**From:** [REDACTED]  
**To:** [A303 Stonehenge](#)  
**Subject:** Proposed Closure of Motor Vehicle Rights on BOAT in Stonehenge WHS  
**Date:** 05 July 2019 19:37:01

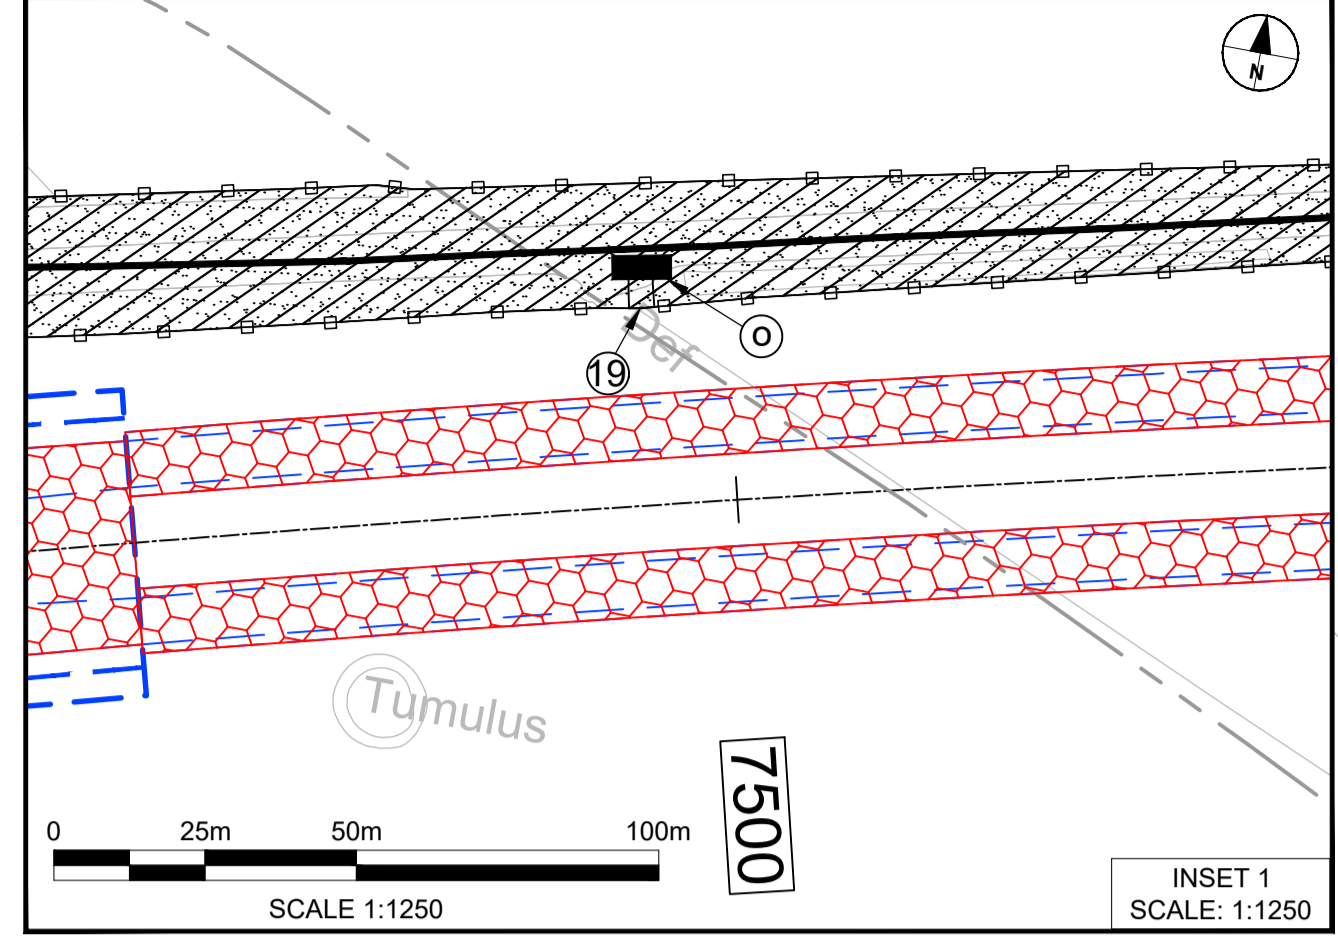
Wiltshire Council reports that Amesbury 12 is becoming heavily rutted. I was the MOD Lands Liaison Officer for 5 years and regularly visited Durrington Down Farm on Durrington 10 and then drove down Amesbury 12 to exit onto the A303, to visit farms nearer to Tidworth.

The deep rutting appears to be on the chalk section i.e. Durrington 10, that has not been metalled. It also appears to have been caused by agricultural use.

I inspected Amesbury 12 and it is suffering from minor pot holing but that is because the route has not been given a camber to encourage proper drainage. I would have used more stone on Salisbury Plain as MOD vehicles, like agricultural machinery, are much heavier than cars and 4 x 4.
